PFOS / PFOA DRINKING WATER MITIGATION SYSTEM

SECURITY WATER DISTRICT (SWD)

Reviewed by
dsdgrimm
03/27/2019 2:10:19 PM

COLLECTION PLAN AND PROFILE

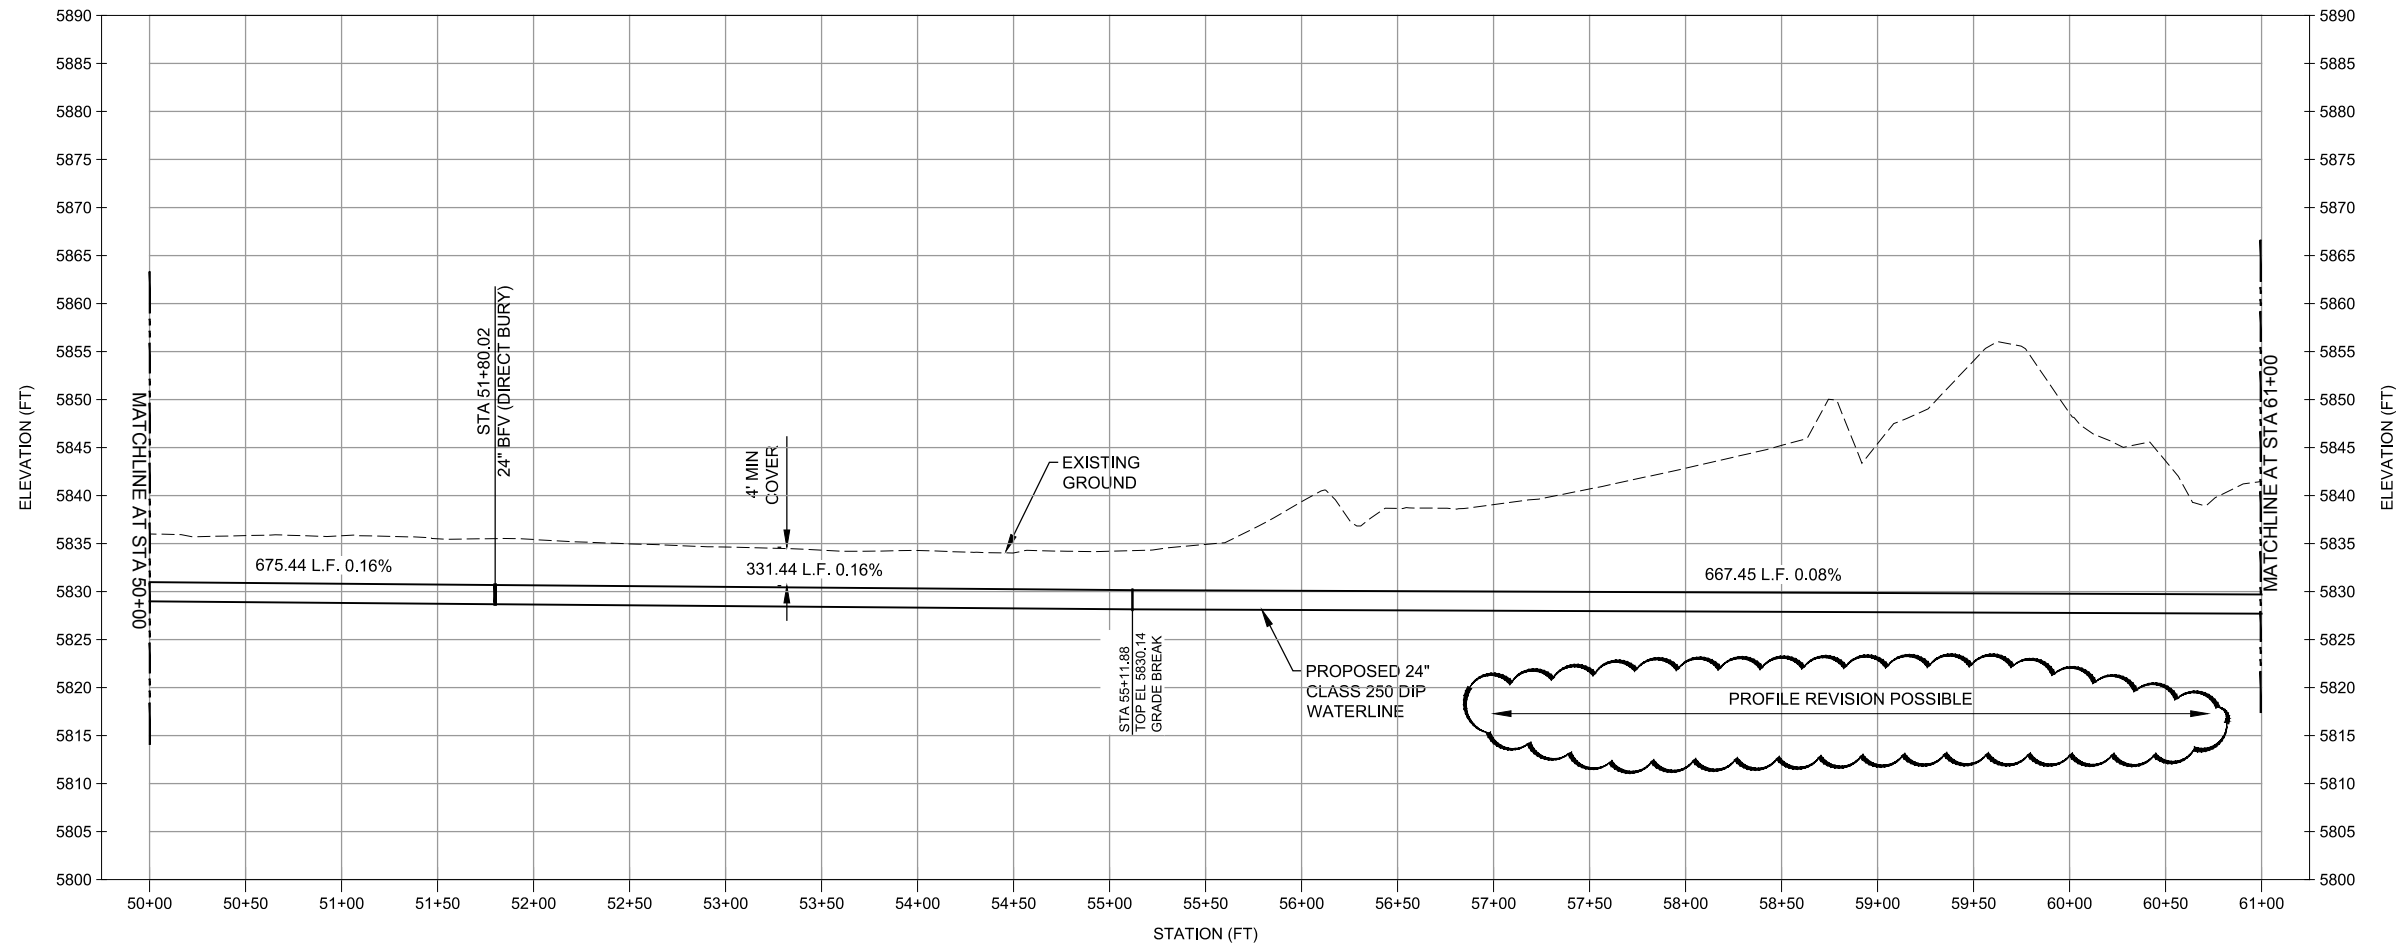
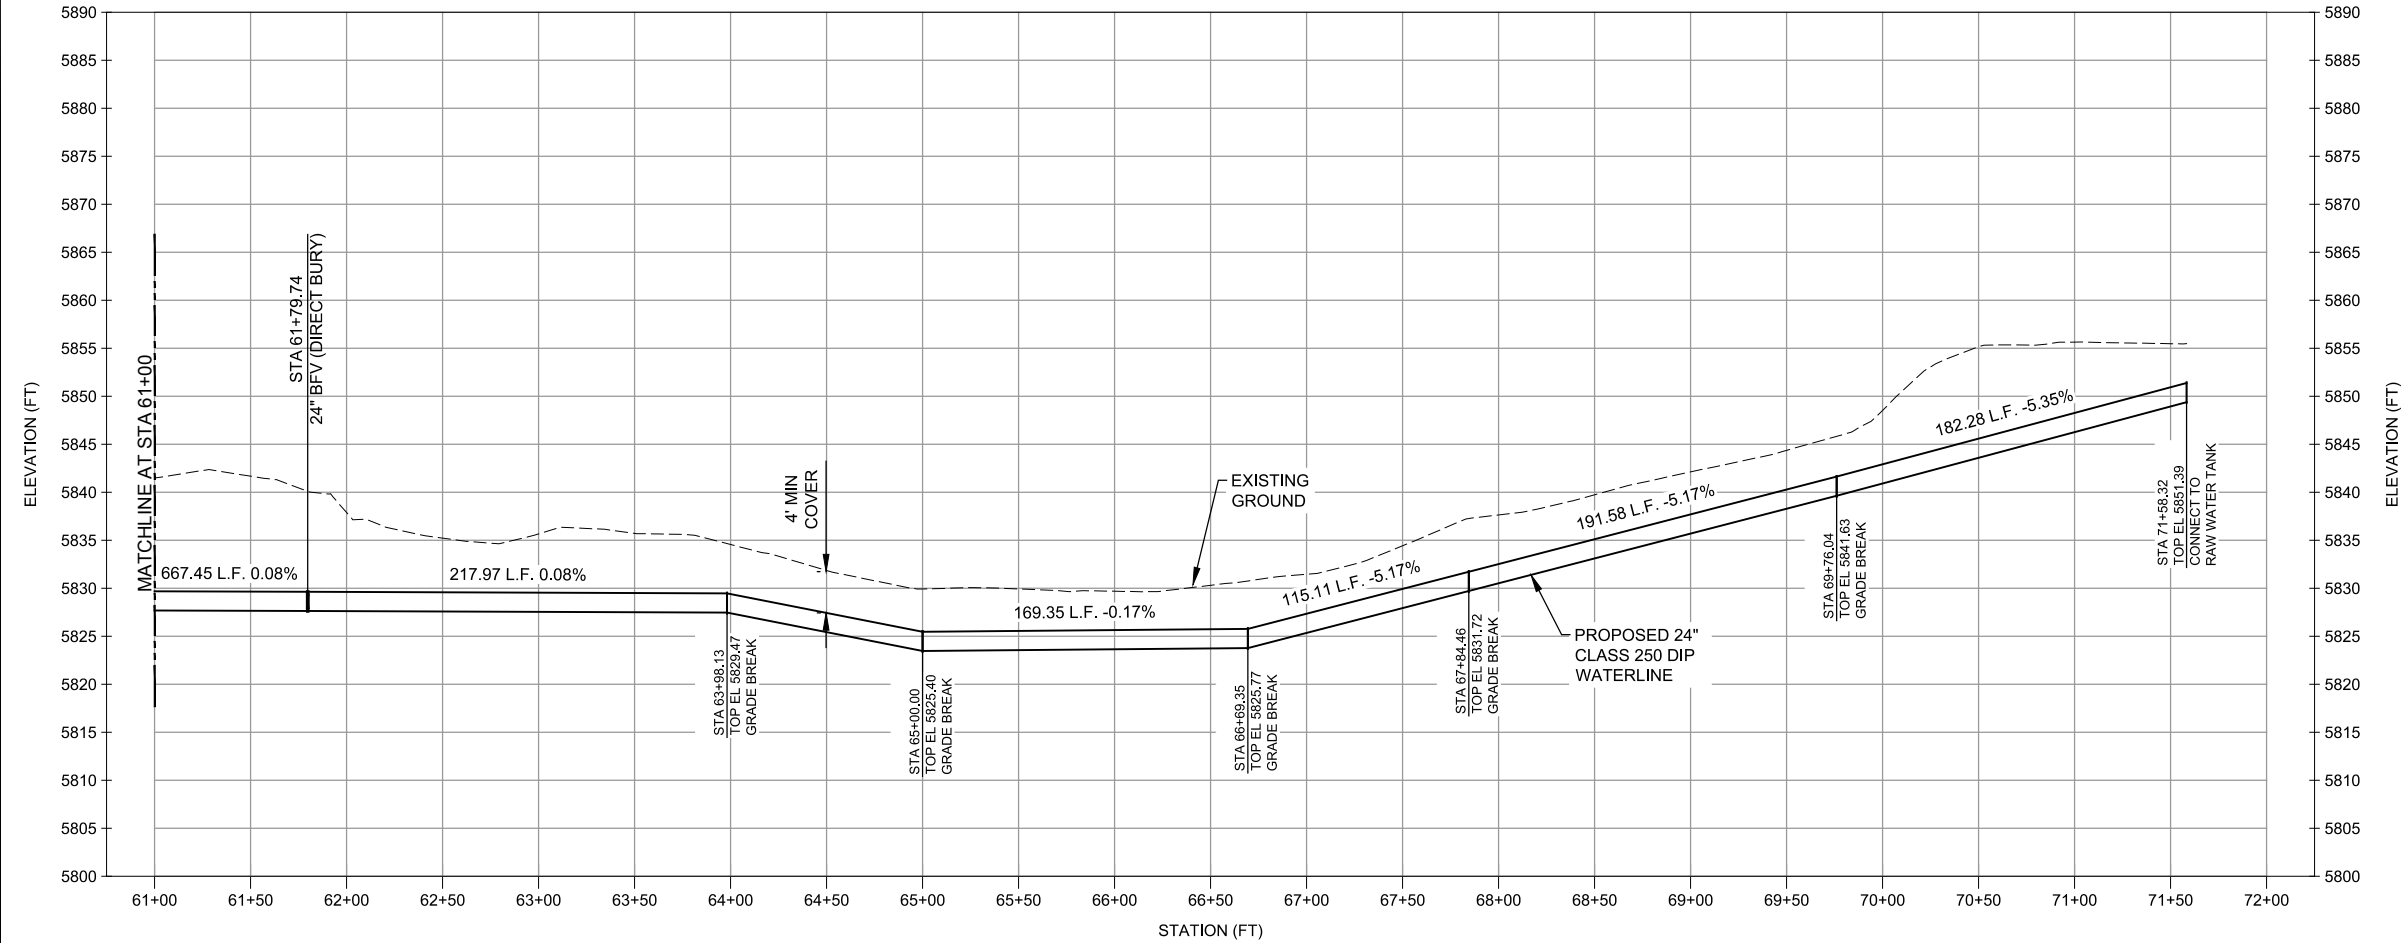
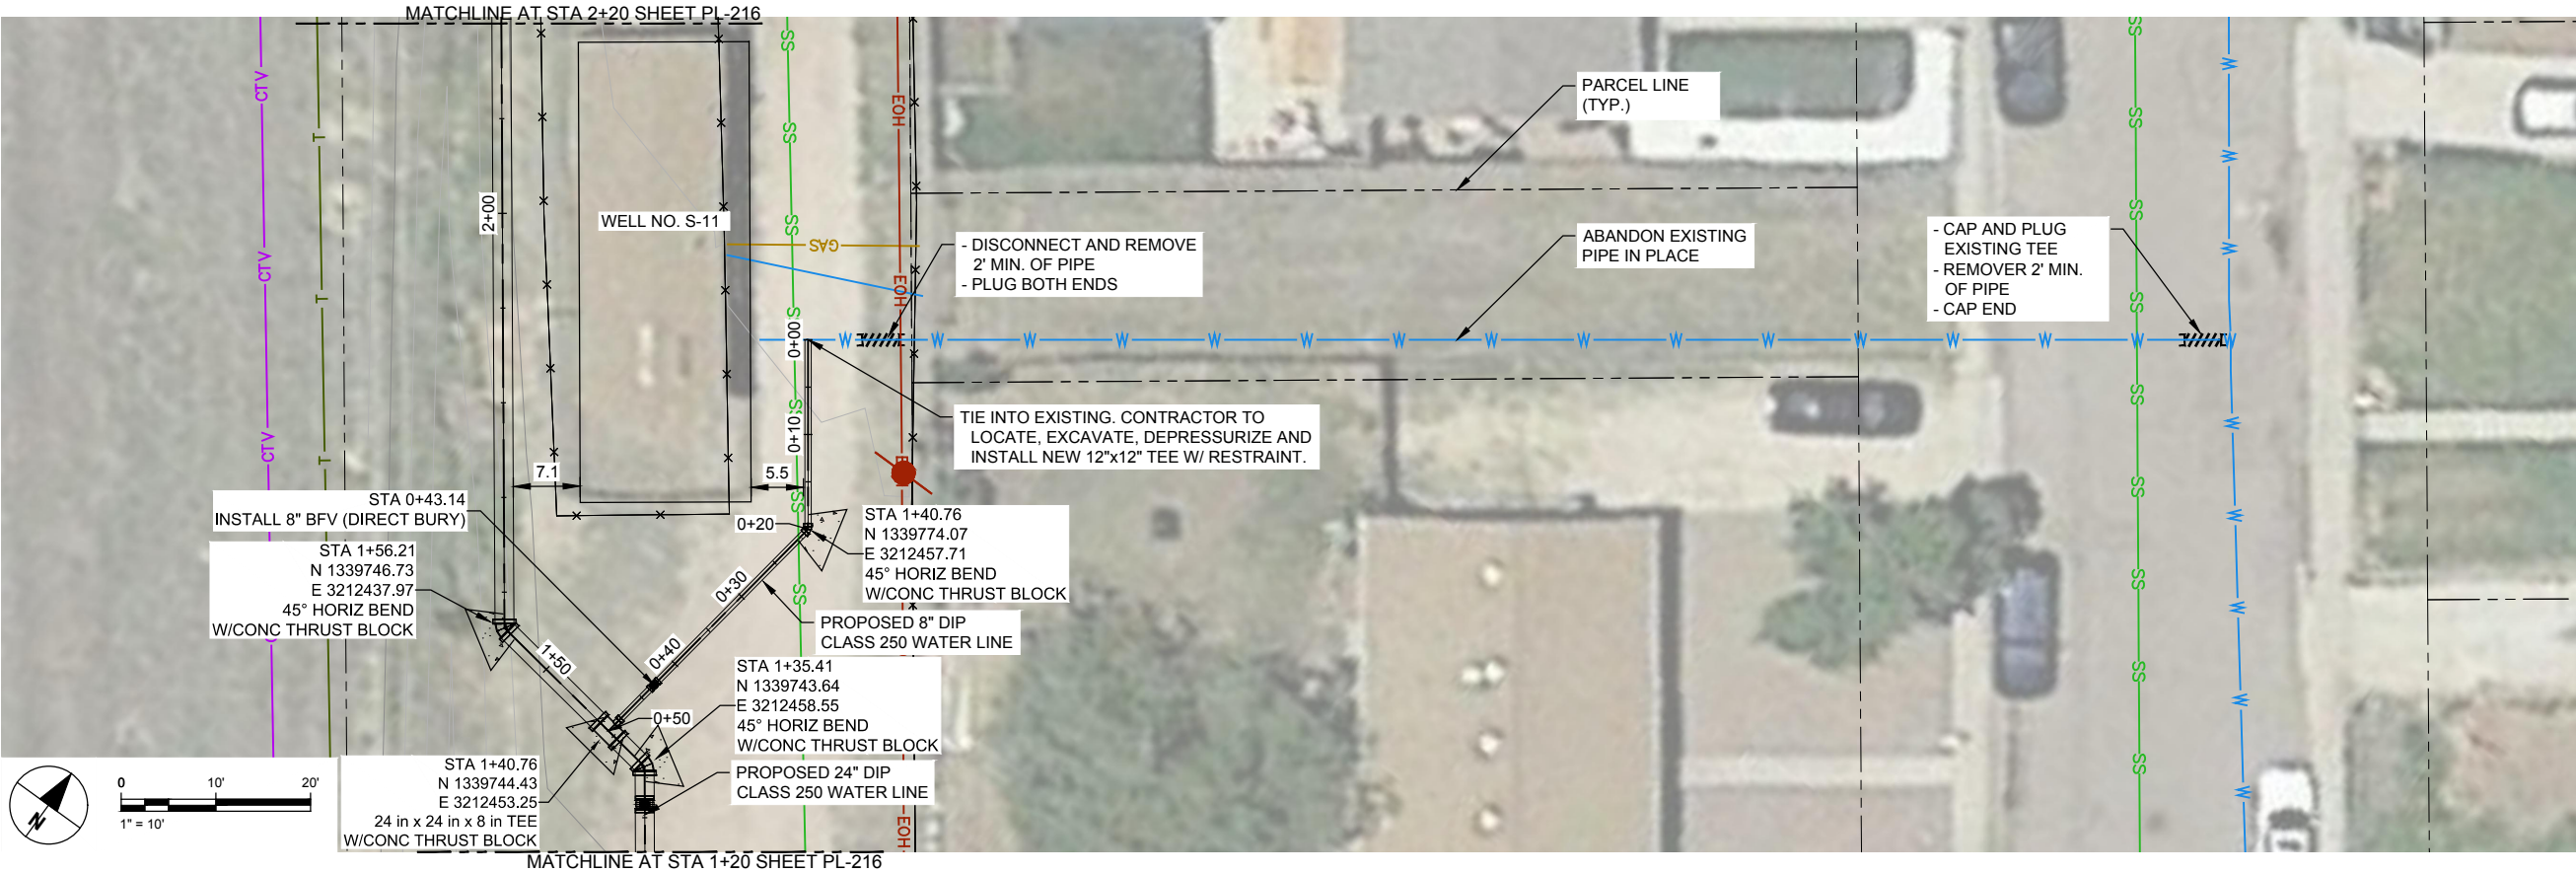
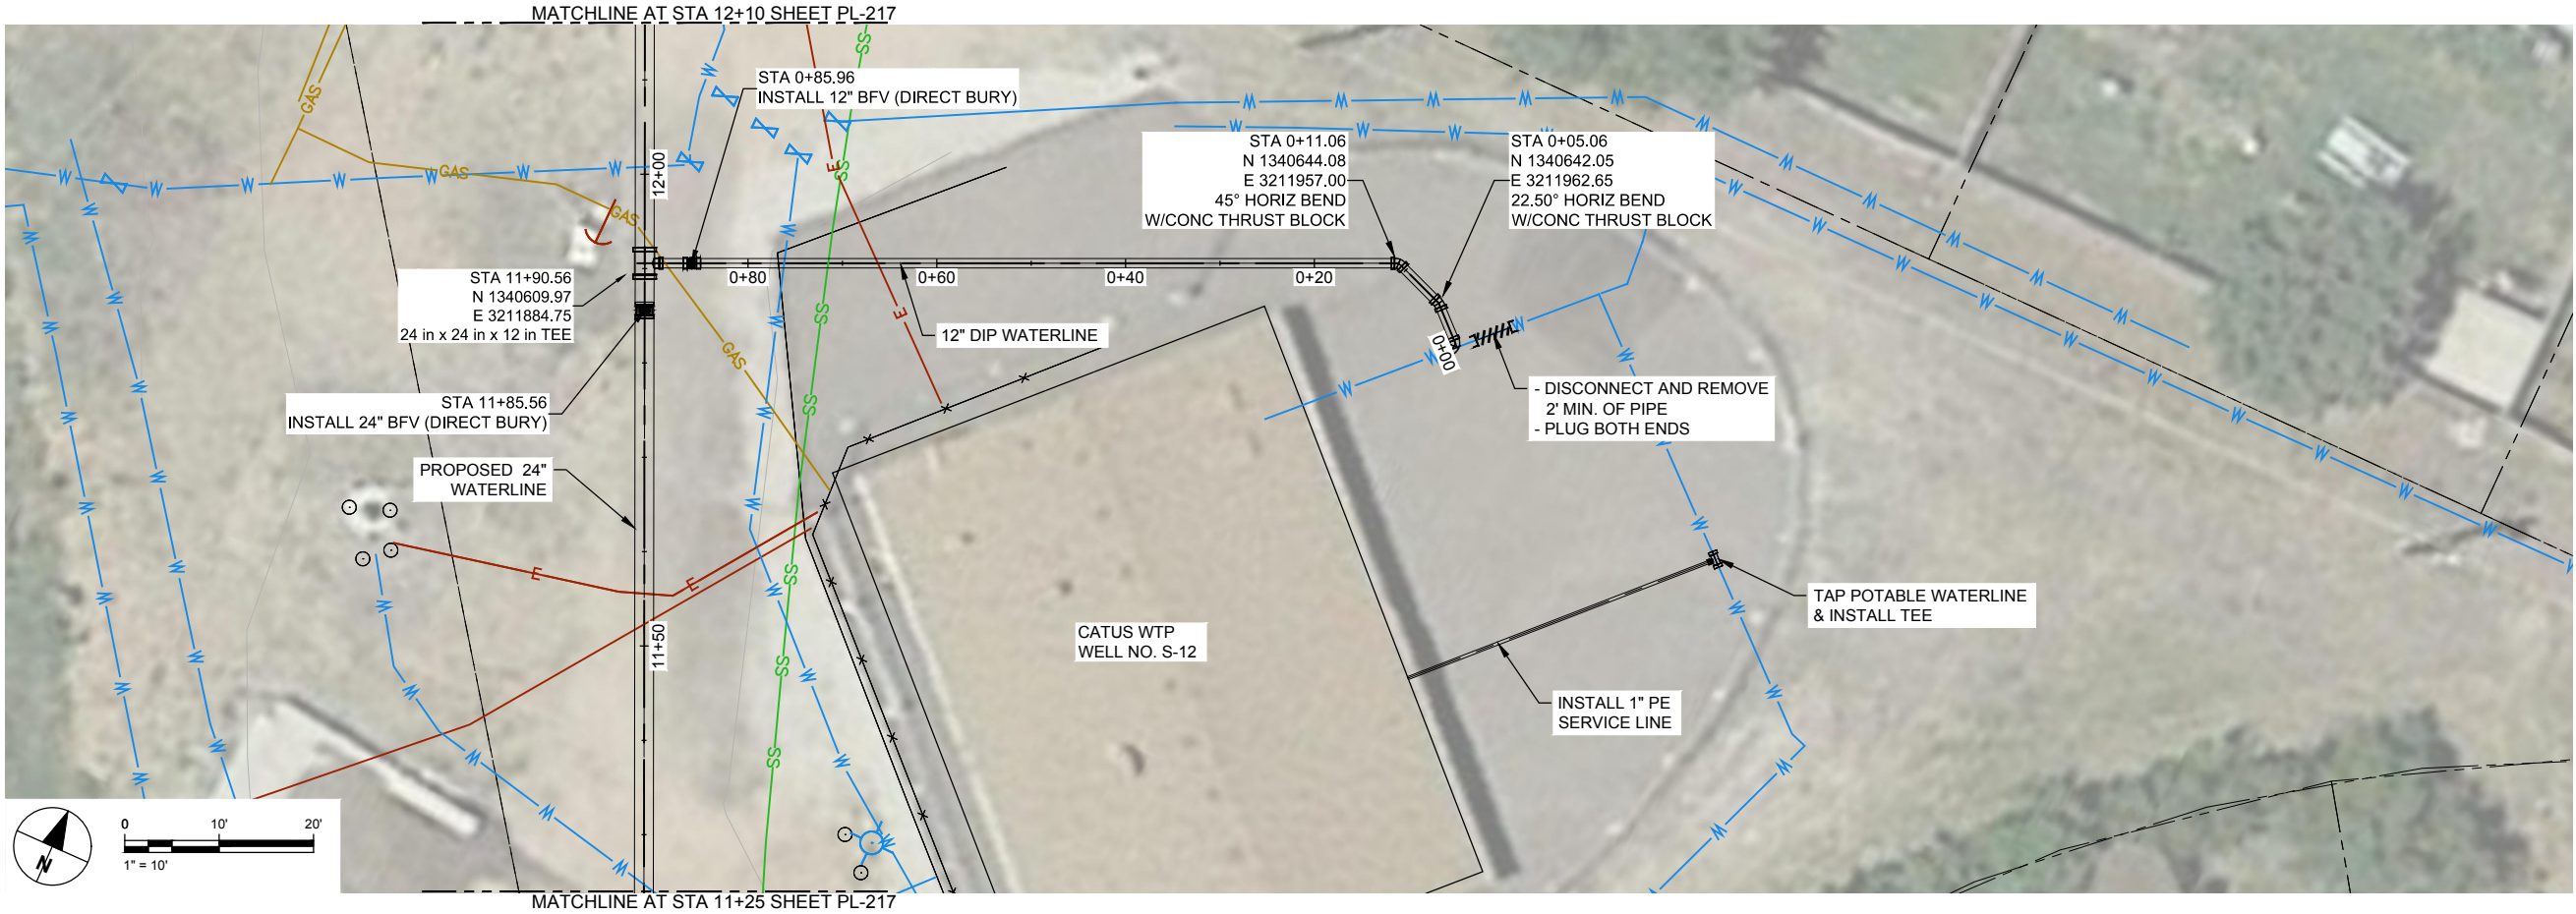
Refer to ECM Chapter 4, Section 4.3.6.A.1 Water Lines. "At no time shall water service lines be placed less than 5 feet in depth measured perpendicularly to the ground line, at any point of the road cross section, to the right-of-way line. It appears that the minimum depth shown in the profiles is 4'. Please revise to meet the ECM standard.
